From: TAYSIR DAWOOD <Taysir.DAWOOD@rms.nsw.gov.au>
To: <andrew.beattie@planning.nsw.gov.au>
CC: <assessments@planning.nsw.gov.au>
Date: 5/4/2012 5:02 pm
Subject: Submission Details for TAYSIR DAWOOD (comments)

Content:
Comments on Homebush Bay Bridge Proposal - Environmental Assessment

Submission for Job: #4331 Homebush Bay Bridge - Project Application
https://majorprojects.affinitylive.com?action=view_job&id=4331

Figure 3.7 – Lane configuration options

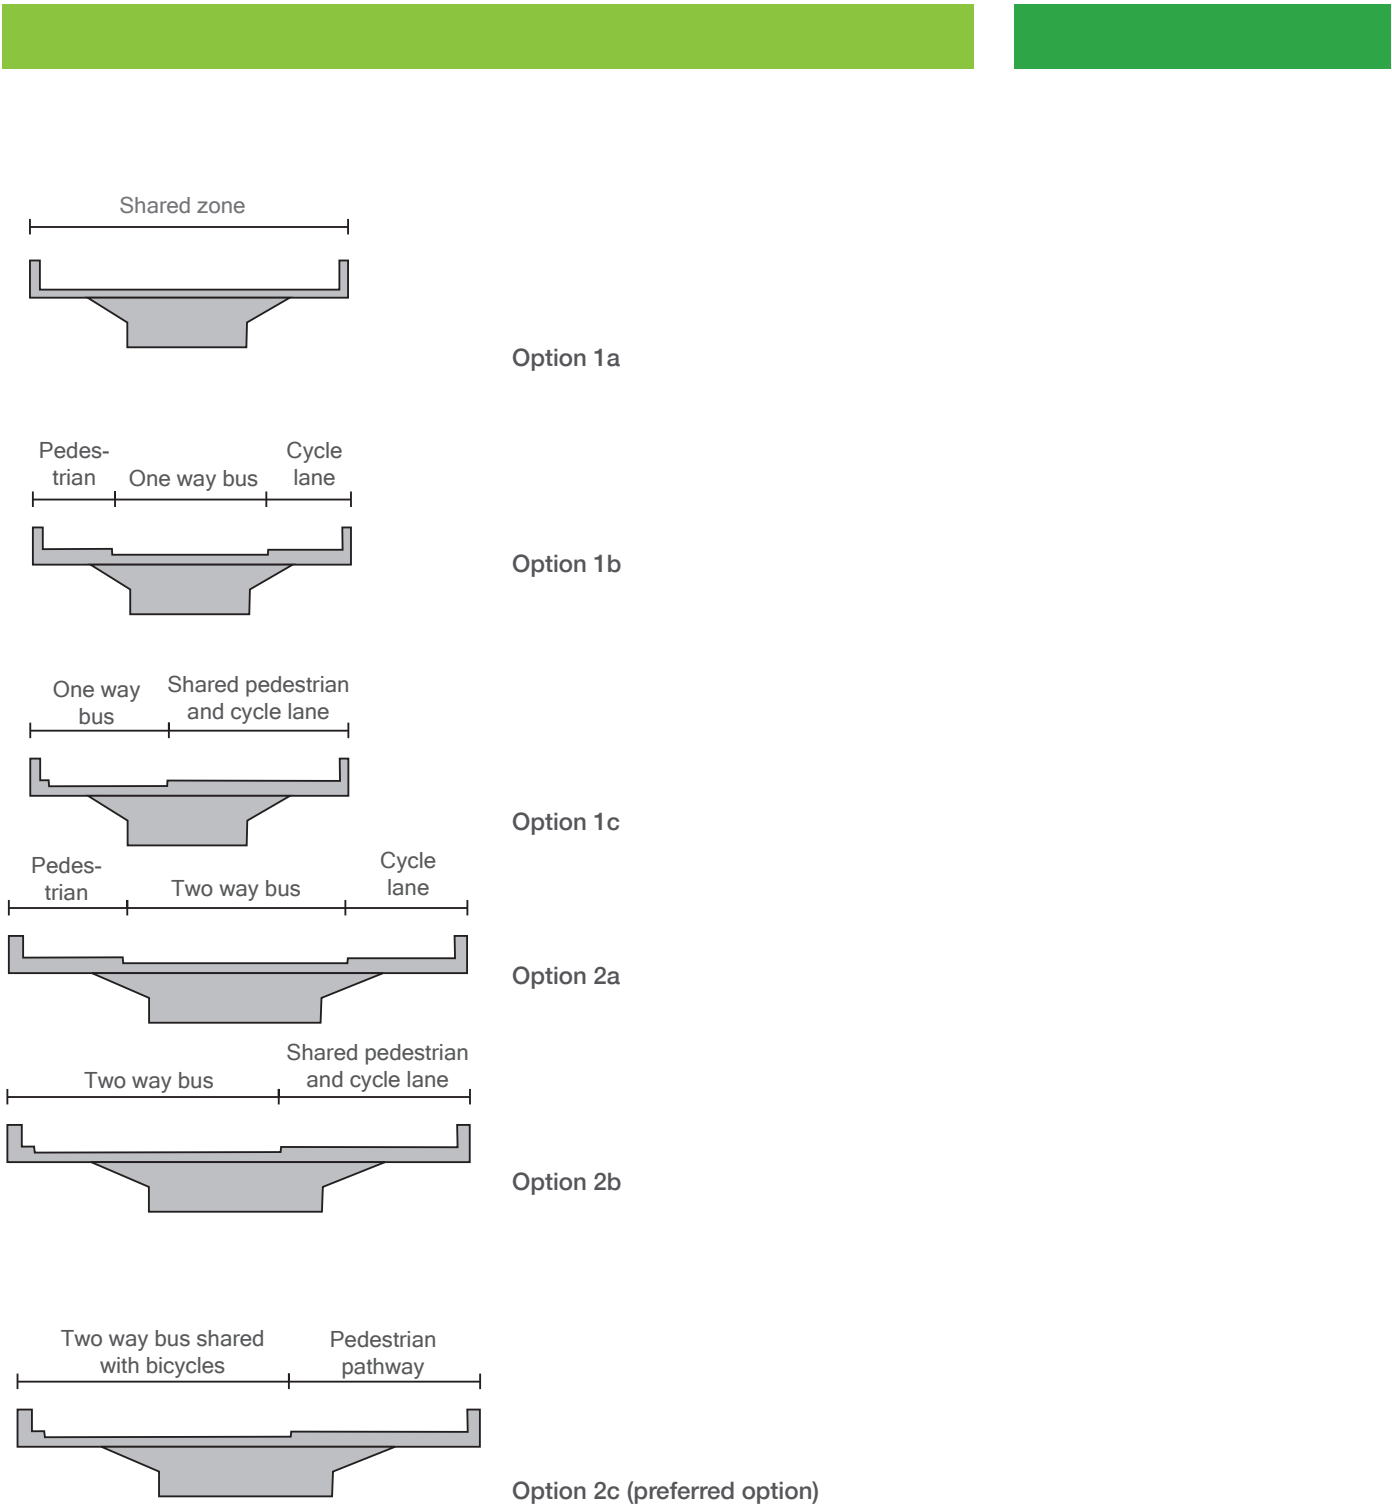
- * The preferred option for the cross section of the bridge and the associated lane width should be further explored and discussed. Option 2C is not supported. The design should aim to provide separate facilities for each of the three user groups (cyclists, pedestrians and buses).
